**RE: Harnett County Land Use Application for Existing Tank # 09-5-22250  
# 09-5-22251**

Based on the criteria set out in Title 15A, Subchapter 18A, of the North Carolina Administrative Code, Rules .1950, the evaluation indicated that the site is **UNSUITABLE** for the addition requested. Therefore, your request for an existing tank is **DENIED**. The site is denied based on the following:

15730 Pof
SITE PLAN APPROVAL

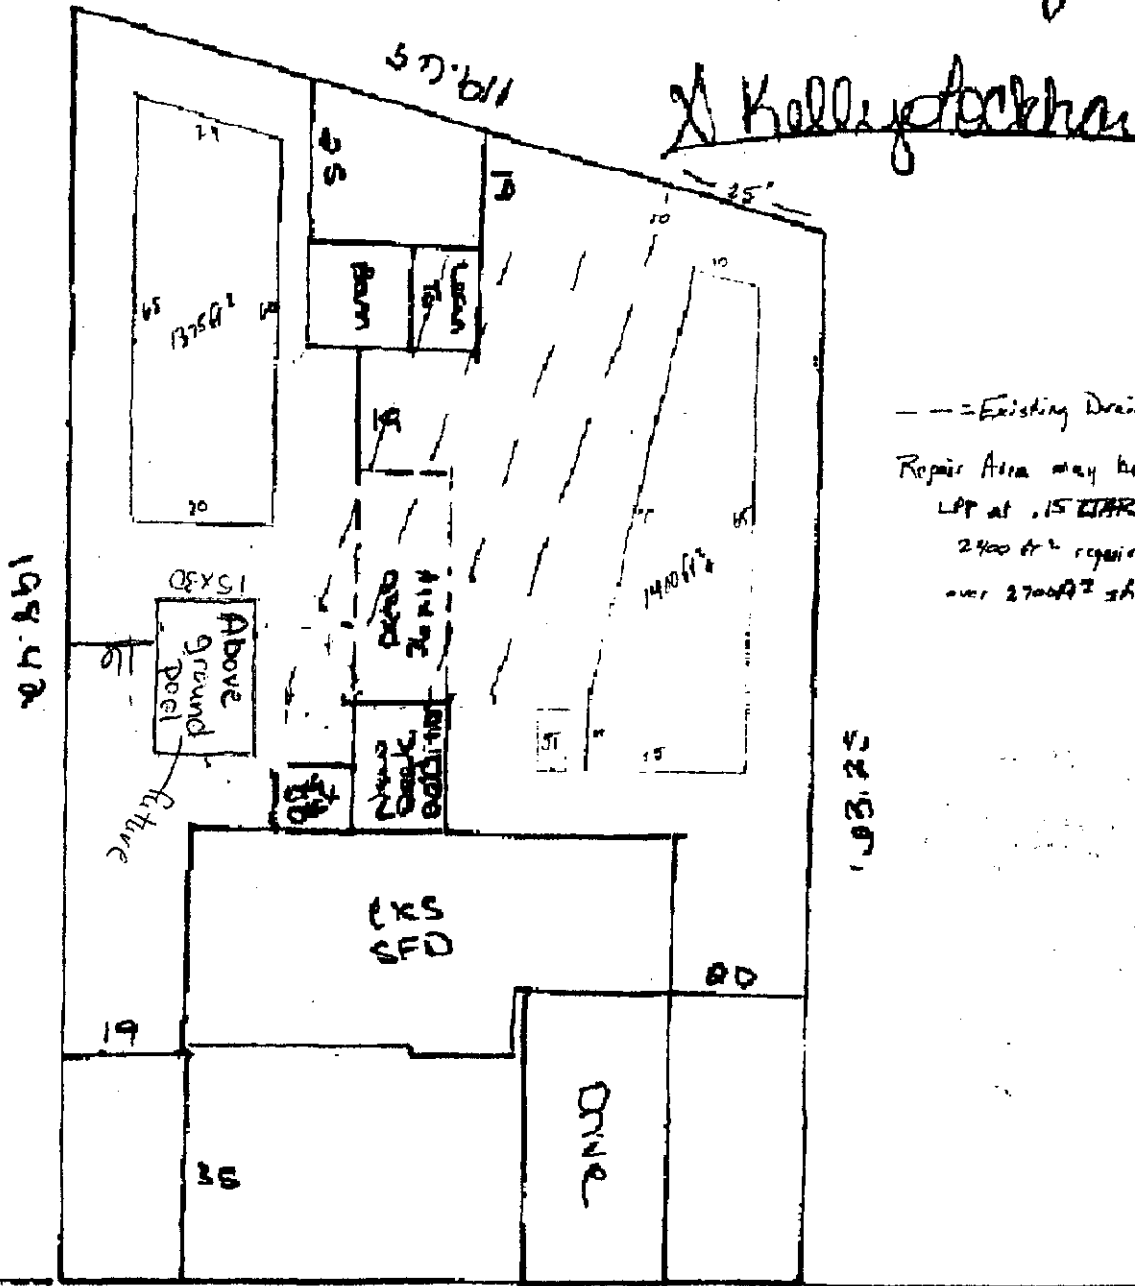
- 15A NCAC 18A.1950 a(16) Any swimming pool must be 15' from any part of septic system.**
- 15A NCAC 18.1945 (b) Each lot shall have original septic system plus repair area.**
- 15A NCAC 18A.1950 (10) – Any building to be 5' from drain line.  
(Barn and addition already exists)**
